Re: Planning Application FG/59/19/HH

PIED A TERRE,

Ferring Street, Ferring, West Sussex, BN12 5JW

With reference to planning application FG/59/19/HH dated 21/5/2019, concerning the old Police House, (described as Pied a Terre in the application), Ferring Street, Ferring, I wish to raise the following objections:-

Client's Name	Drawing Title	Drawn	Date
Tony Maio	Proposed Floor Plans	FS14	15.05.19
Job Title	Scale	Rev	01
Ferring Street Ferring West Sussex BN12 5JW	1:100

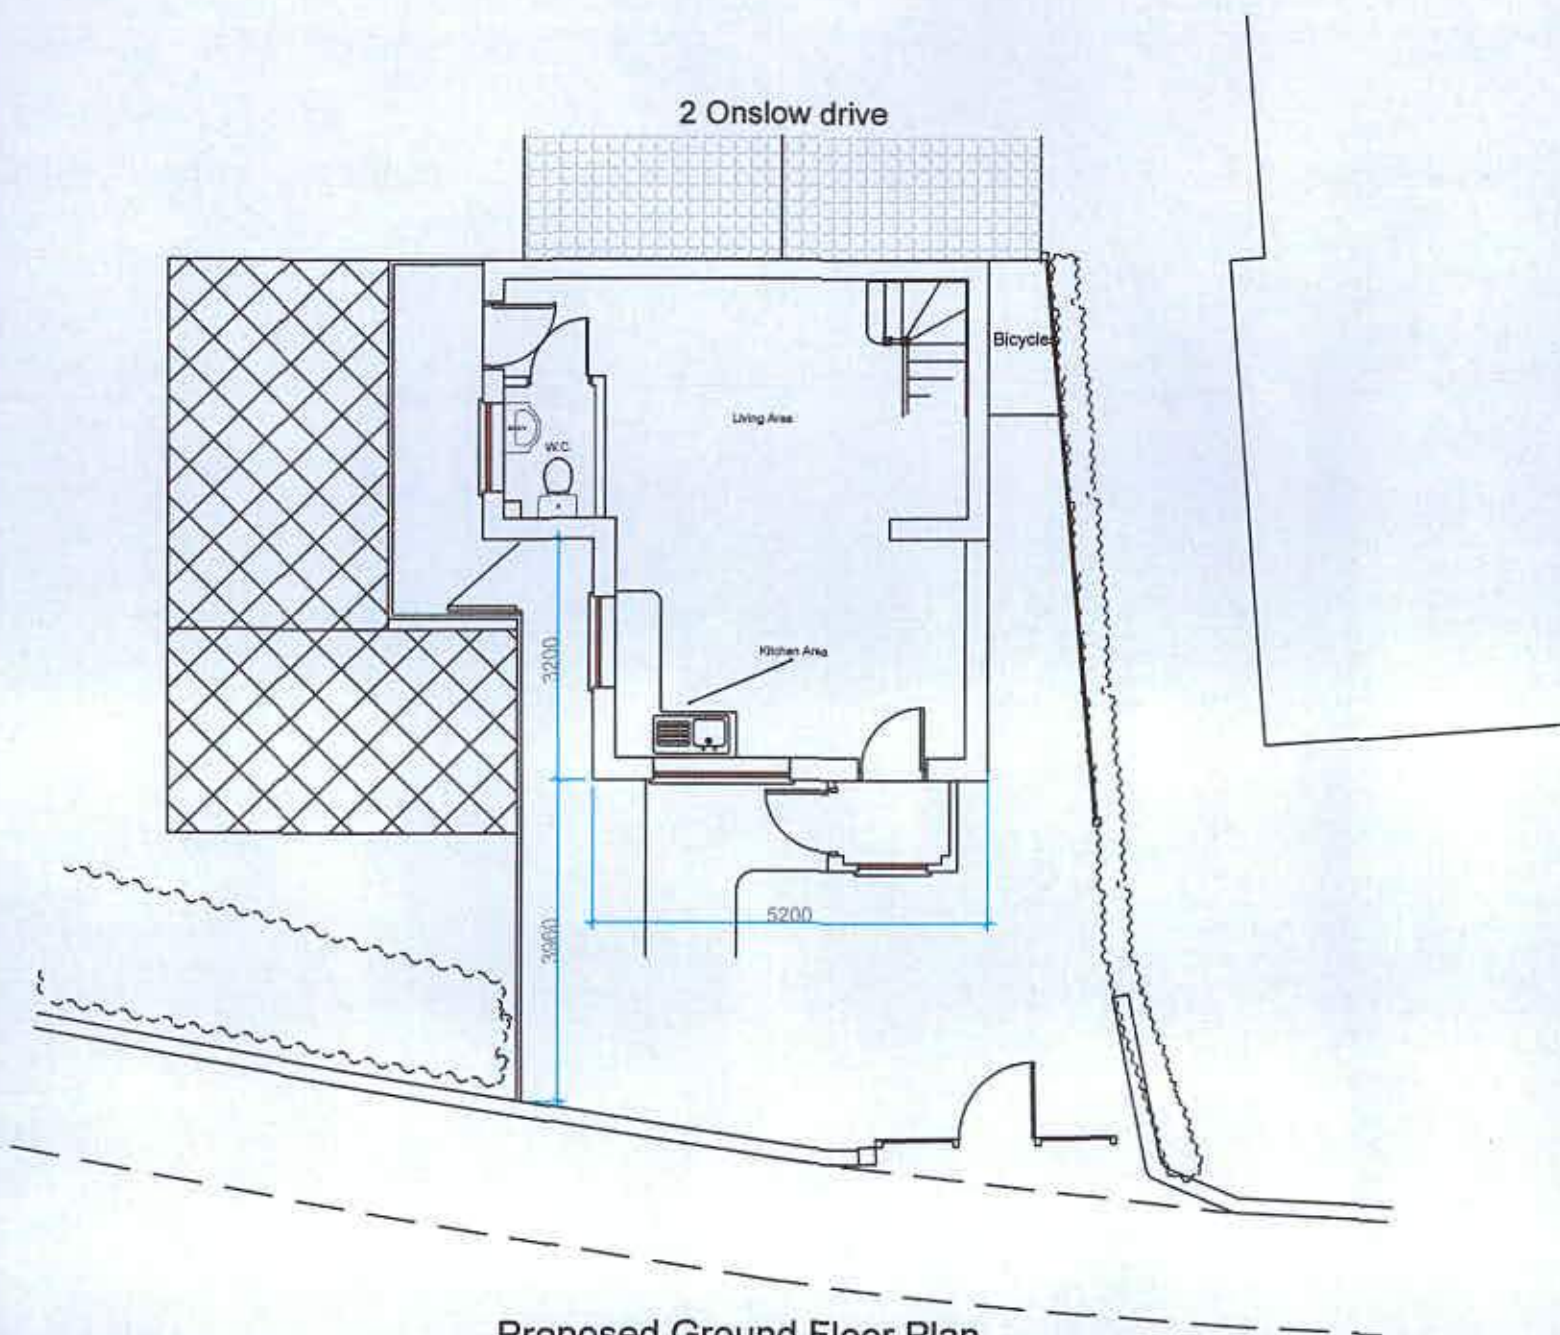
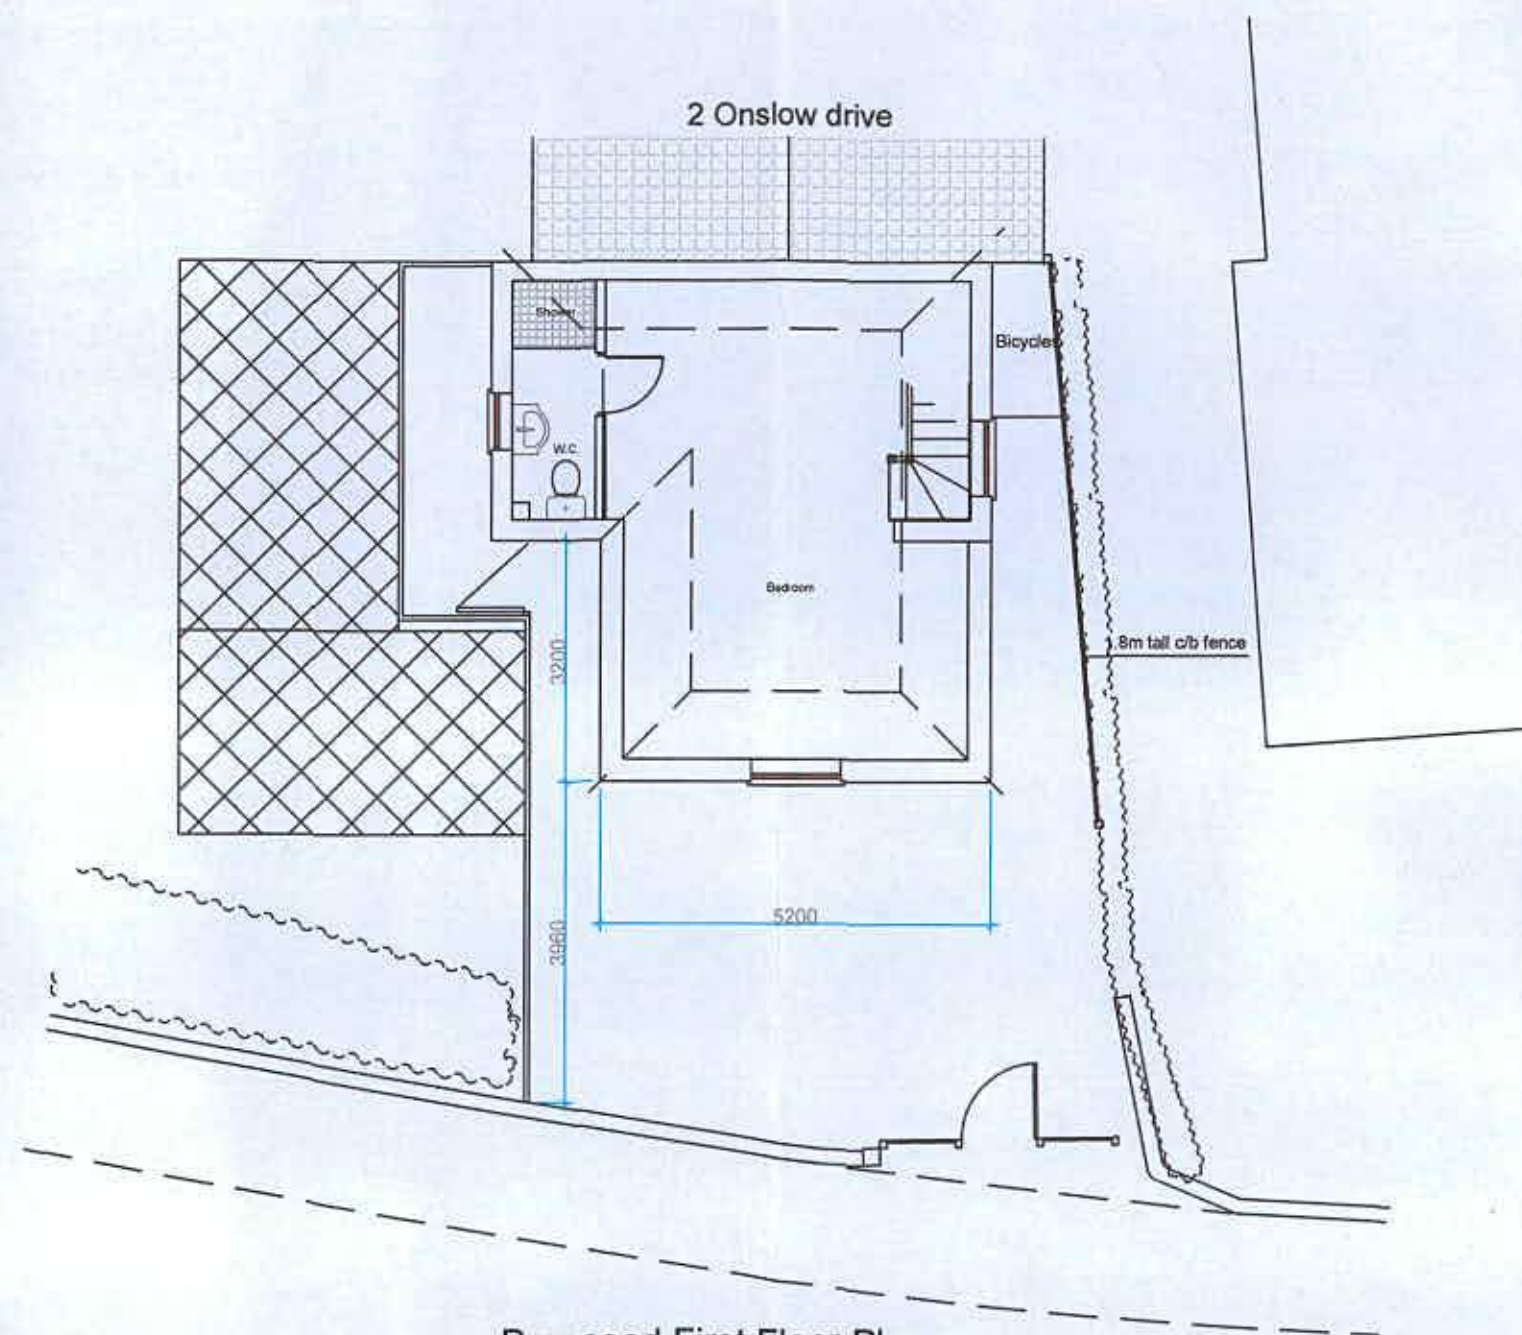
- 1) If the plans are implemented, it would be a massive over-development of the area.
- 2) The occupiers will not have any car parking space & will have to park on the street, thereby reducing the number of spaces for shoppers by one or two spaces.
- 3) The boundary trees between the proposed development & the Pump Court flats at 39, Ferring Street would be within falling distance of the proposed development & their roots would be damaged by the new foundations necessary for it.
- 4) The proposed development would lead to a loss of light & privacy for the occupants of the Pump Court flats. The height & depth of the proposed extension would completely block out sunlight to the two ground floor flats. The flats have enjoyed unobstructed light for more than fifty years.

Client's Name	Drawing Title	Drawn	Date
Tony Maio	Proposed Elevations/ Street Scene	FS15	15.05.19
Job Title	Scale	Rev	
Ferring Street Ferring West Sussex BN12 5JW	1:100	01

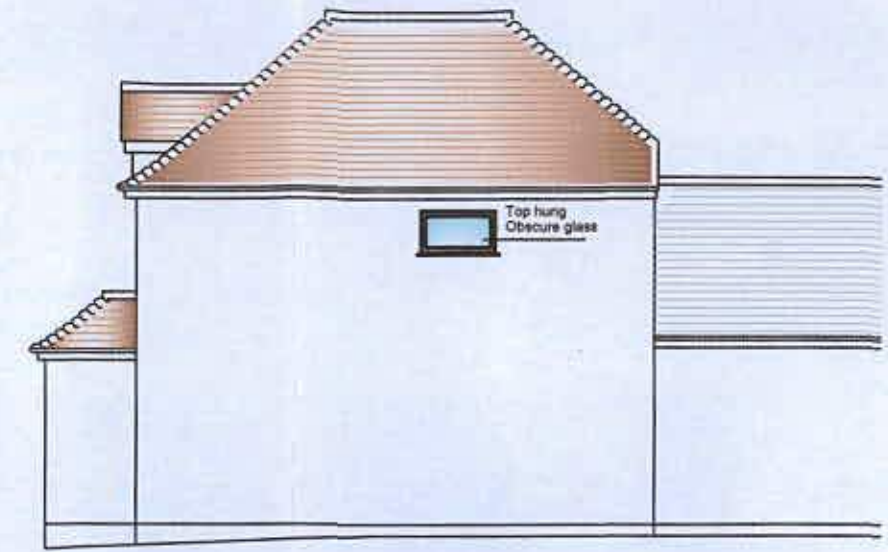
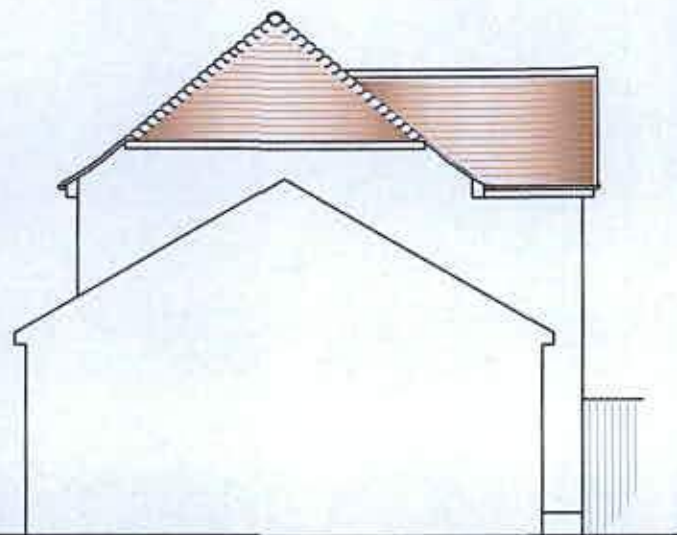
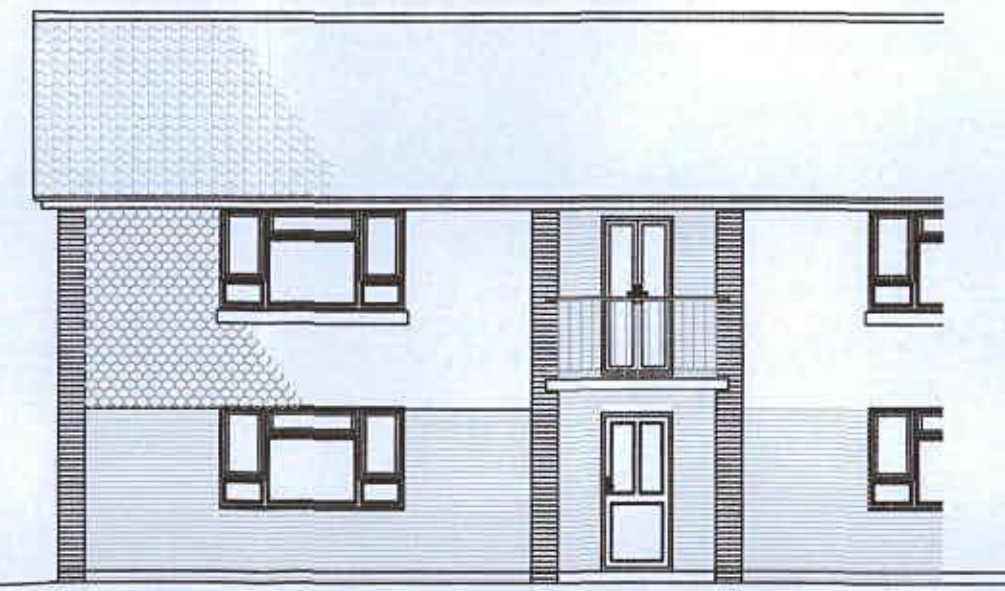
Furthermore, with regard to privacy, it is very common that a window with obscure glass is subsequently replaced with one of clear glass, (north elevation, overlooking sunny hard-standing seating area for the two south-facing flats.)
